**Environment  
Agency Relevant  
Representation on  
Sizewell C  
Development  
Consent Order**

Our Reference: AE/2020/125515/01

September 2020

DRAWING NO:
SZC-SZ0100-XX-000-DRW-100205

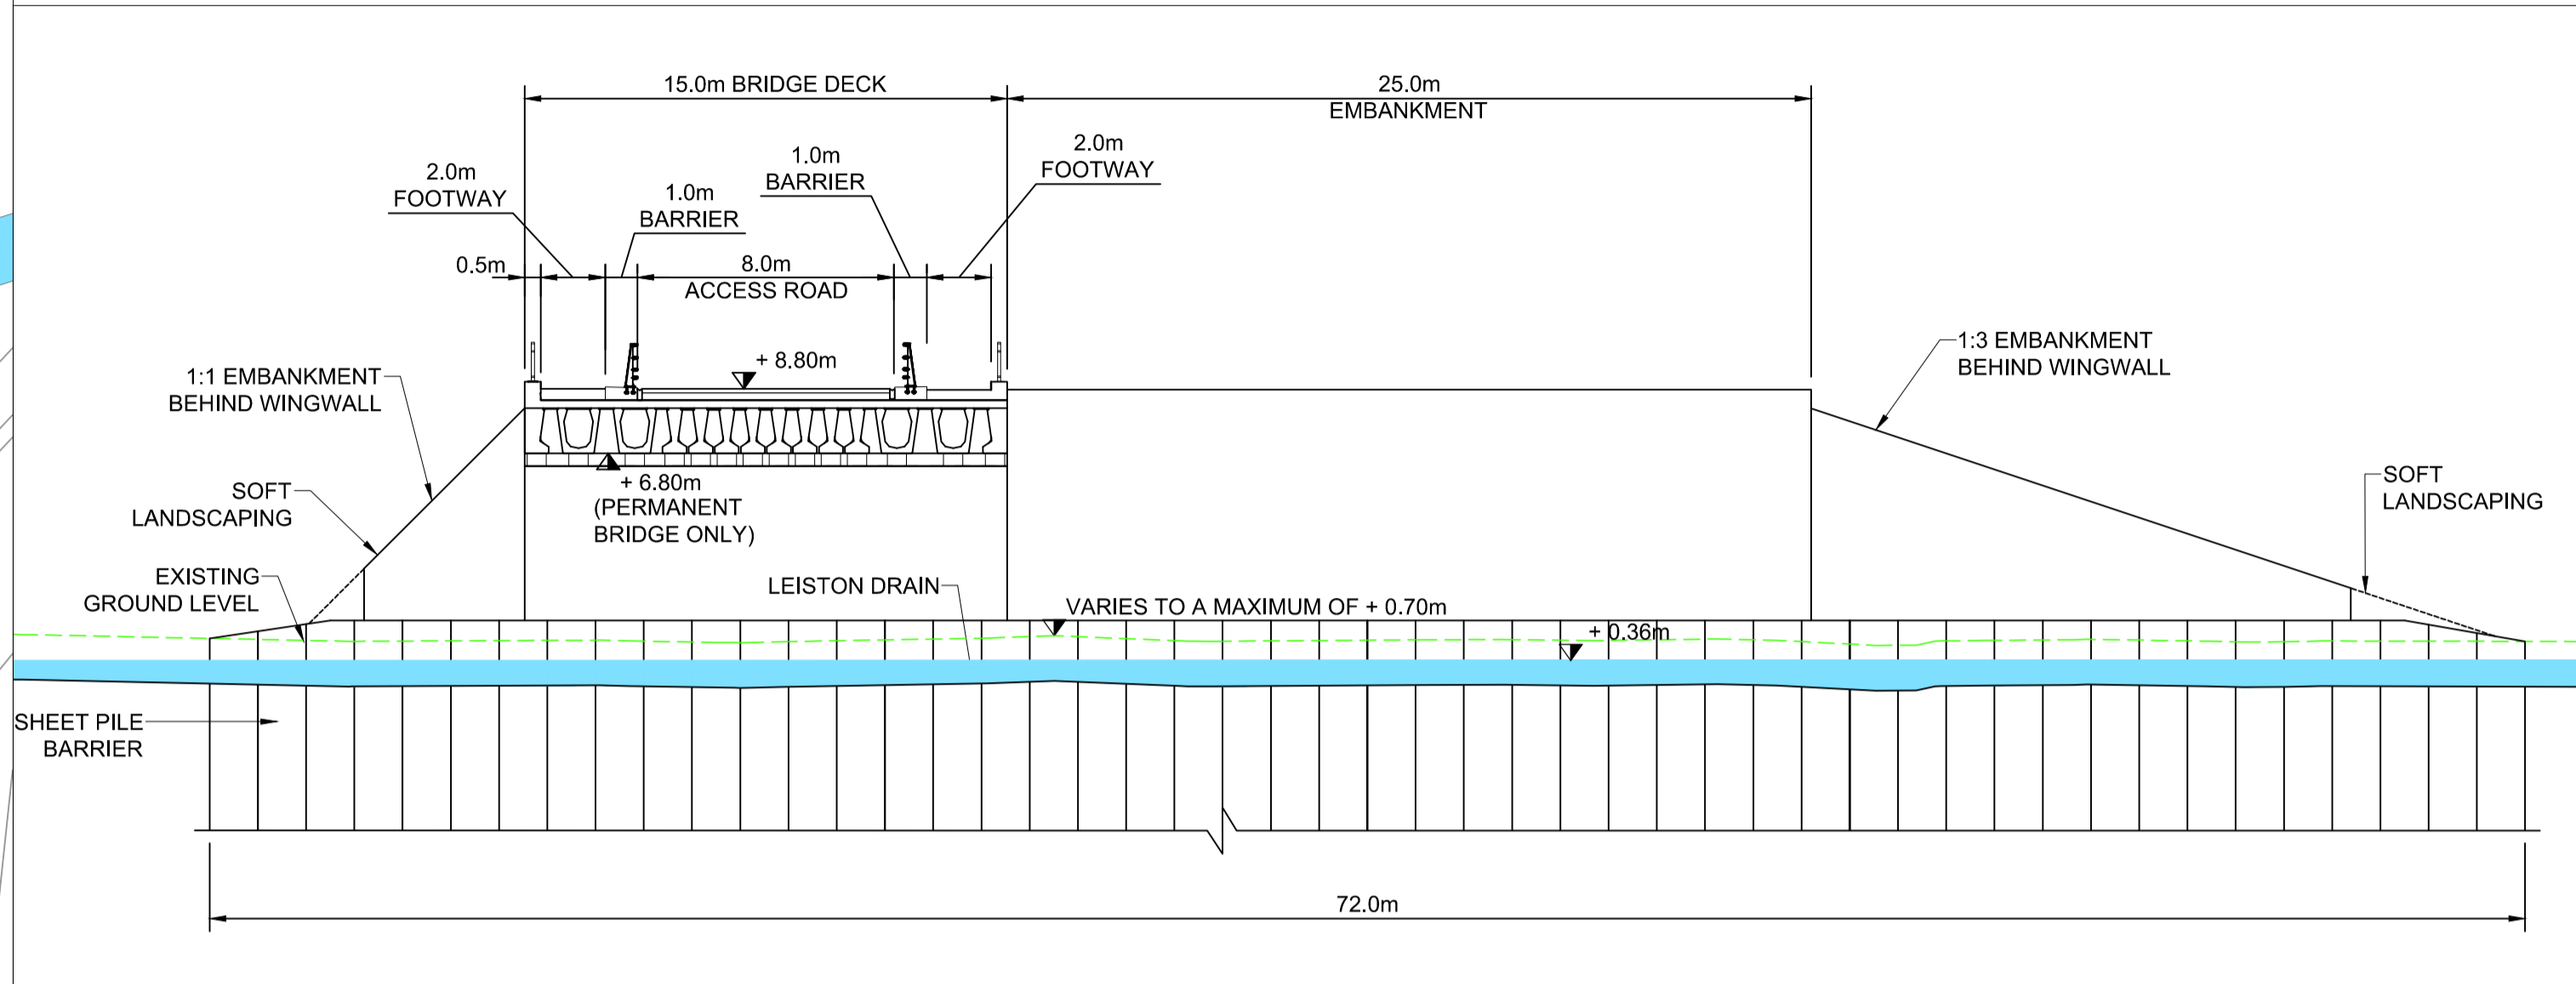
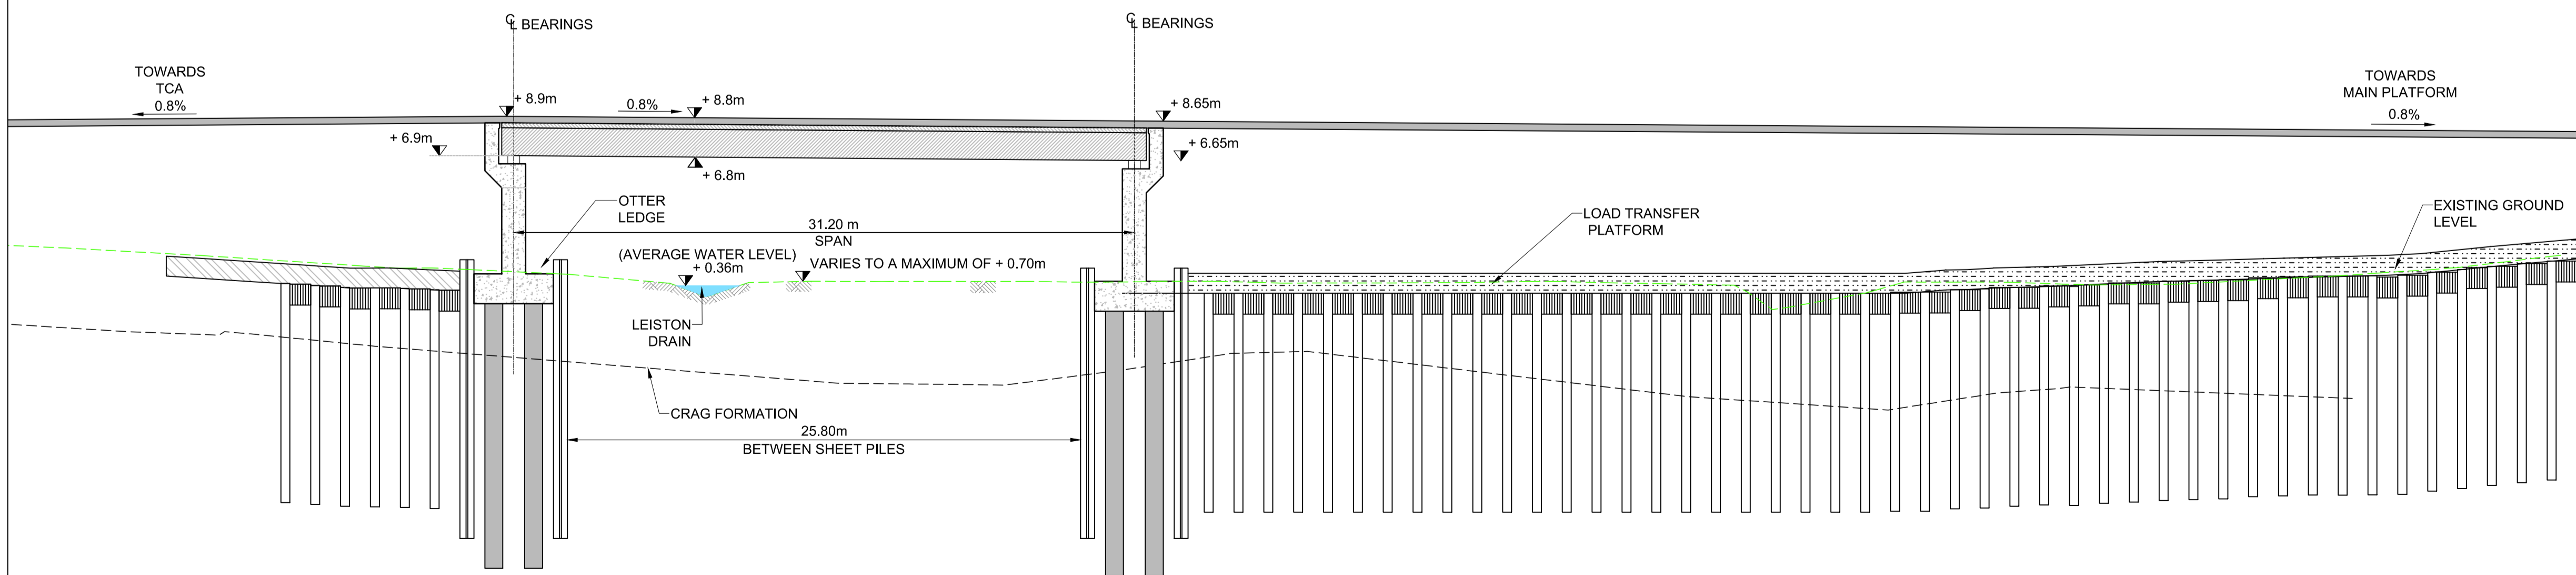
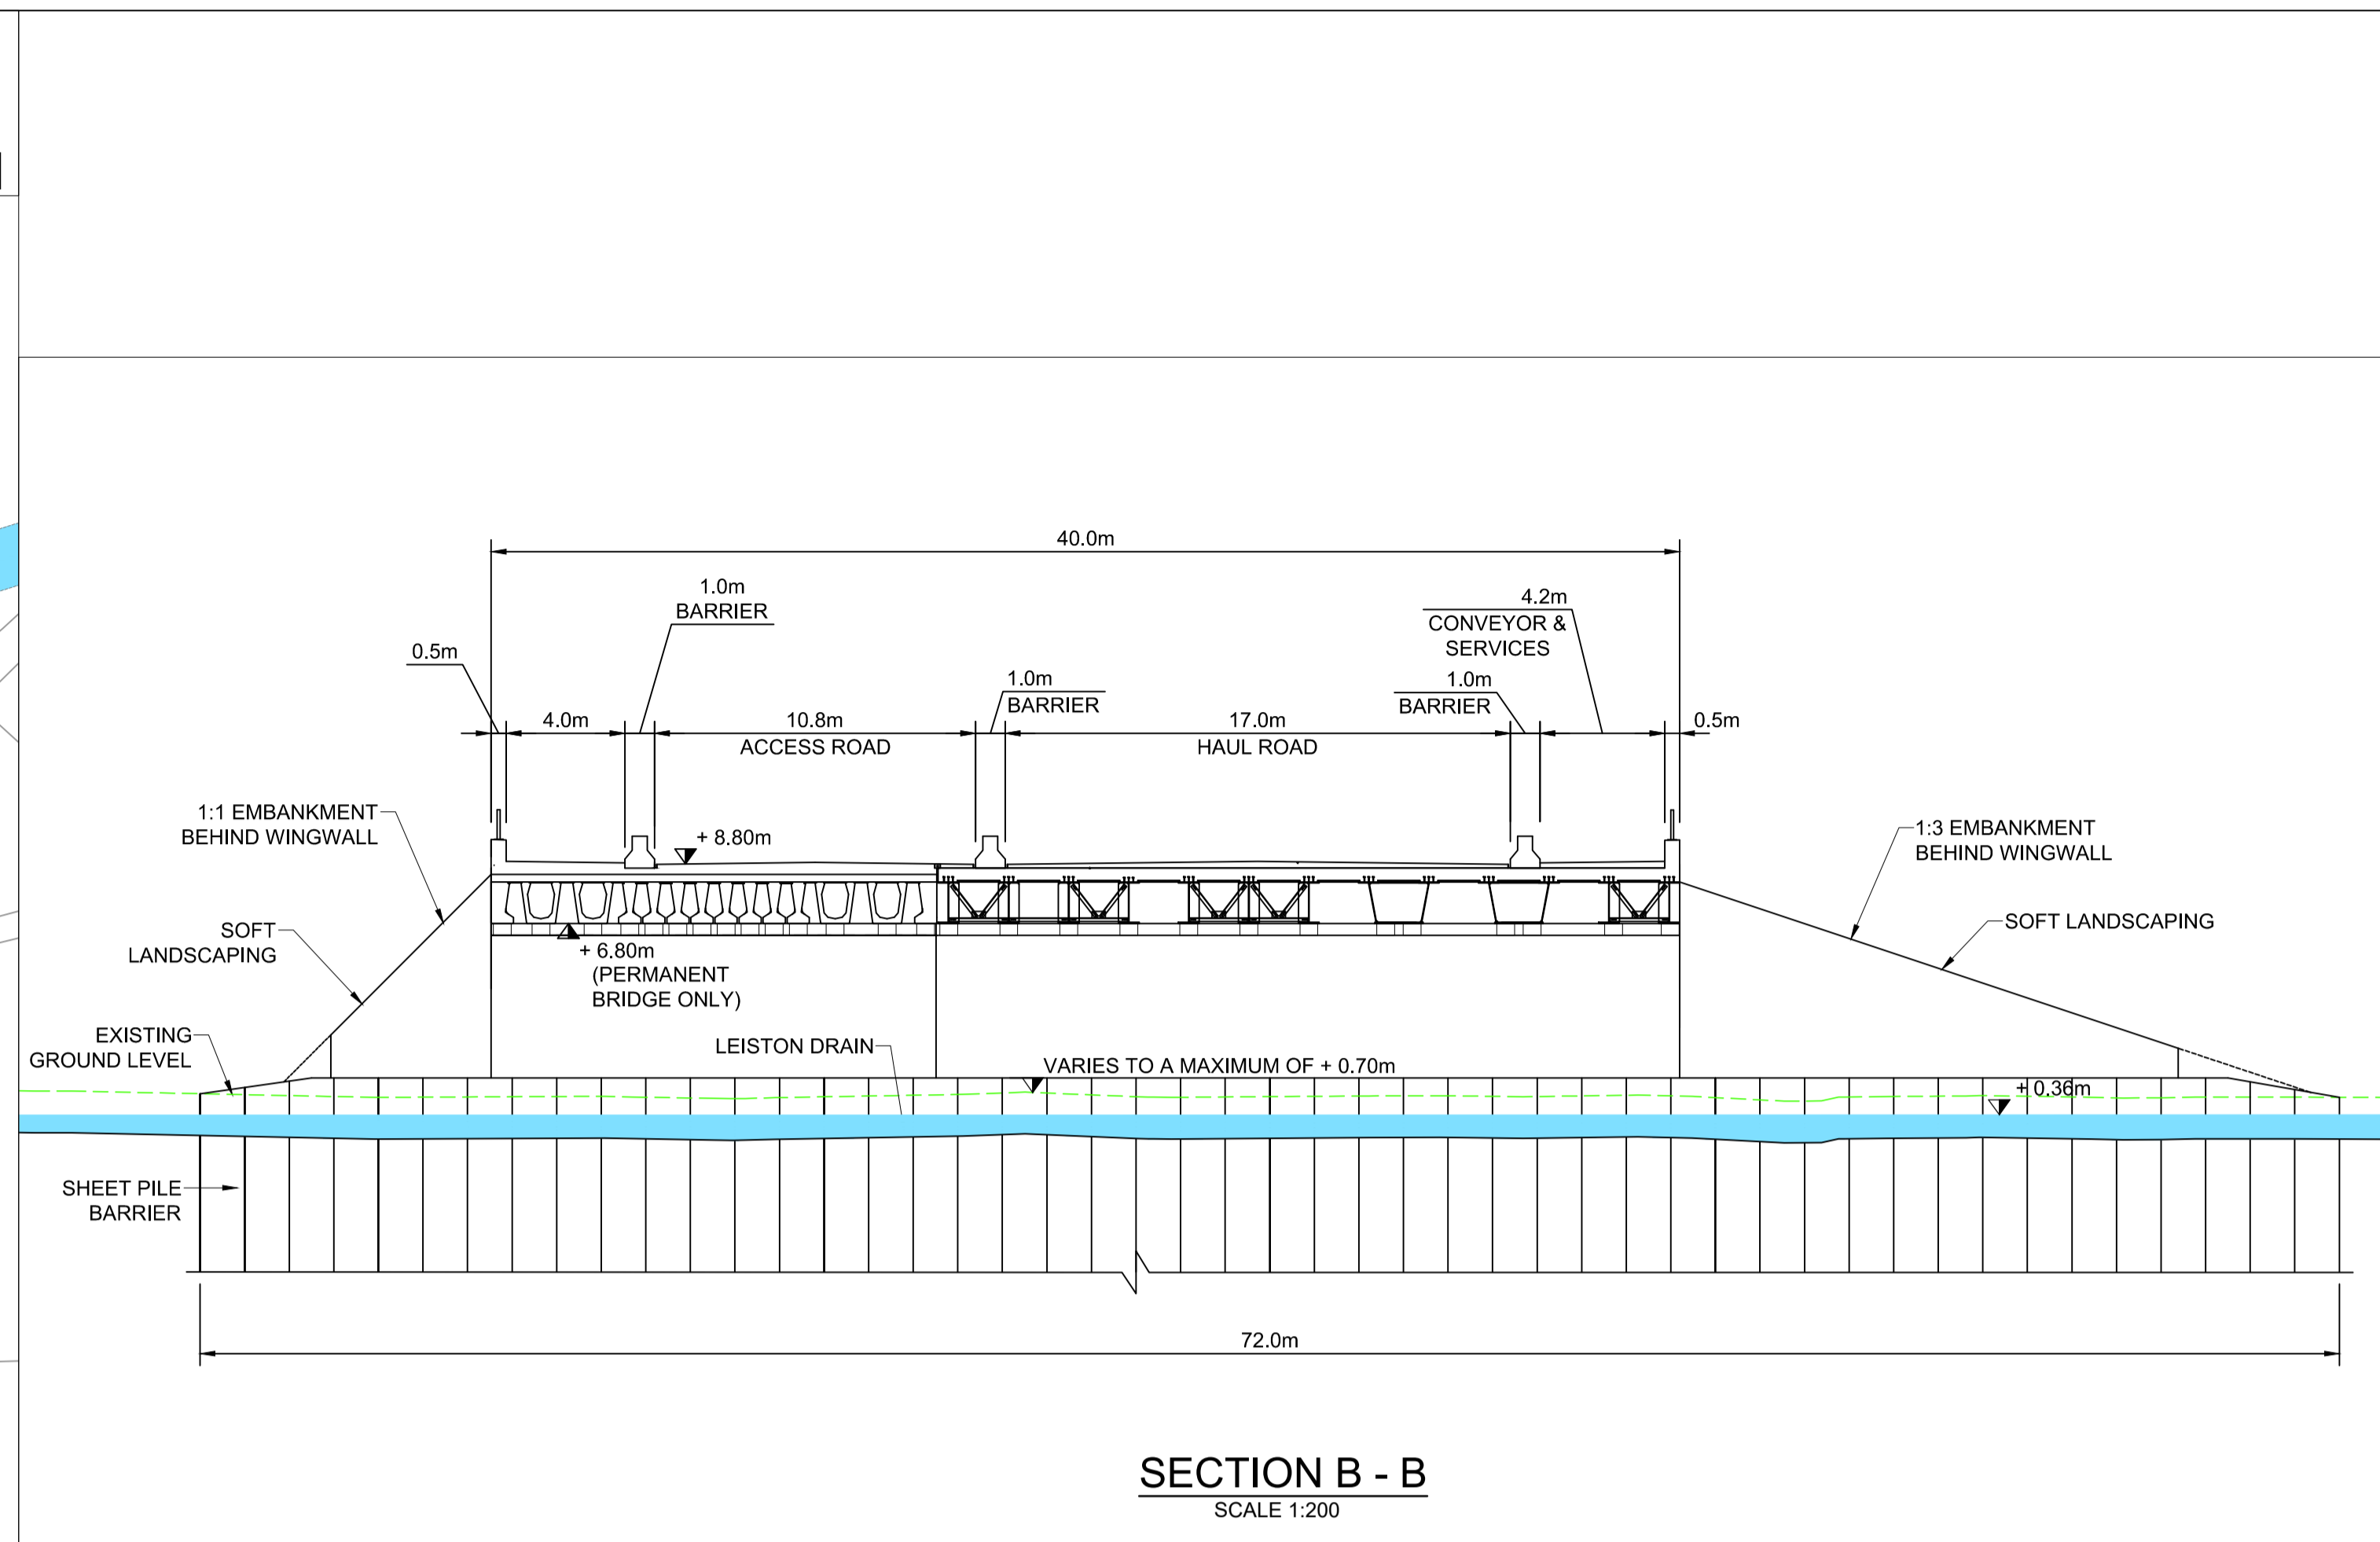
- 6.0 The proposed design of the SSSI crossing across the Leiston Beck is unacceptable because of the significant permanent direct land take from the SSSI, the impacts to ecology caused by construction of the culvert along the length of the watercourse, and the permanent habitat fragmentation that it would cause. We do not consider that a suitable alternative has been considered adequately, and we reject certain statements within the submitted reports that suggest the Environment Agency would find culverting to be acceptable without further evidence of environmental suitability or compensation.

- 6.1 The culvert and embankment design has high direct land take - at 0.40ha - and is more than double the land take of a three span bridge option at 0.19ha. We cannot conclude that the culvert design proposed (70m in length with a cross sectional area of 22m<sup>2</sup>) will allow for the movement of otter, water vole, aquatic and terrestrial invertebrates, and fish. This culvert could prevent the upstream and downstream migration of numerous species either side of this significant structure approximately halfway along the river, and its associated SSSI designated habitat.

- 6.7 **Otter:** no evidence has been provided that demonstrates a culvert of the dimensions proposed to cross the Leiston Beck would facilitate the passage of otters (protected species, Wildlife and Countryside Act 1981). Some reports

- 6.8 **Water vole:** No evidence has been provided that demonstrates a culvert of the dimensions proposed to cross the Leiston Beck would facilitate the passage of water voles (protected species W&C act 1981).

- 6.12 **Fish:** No evidence has been provided that demonstrates a culvert of the dimensions proposed to cross the Leiston Beck would facilitate the passage of fish along this watercourse. Culverts can inhibit fish movement as the abrupt change in light and extended length of dark, un-vegetated and featureless watercourse is known to prevent fish movement. This can lead to large scale fish mortality when fish are prevented from moving along a watercourse during events when water quality is reduced to a critical level, such as algal blooms, or pollution events.
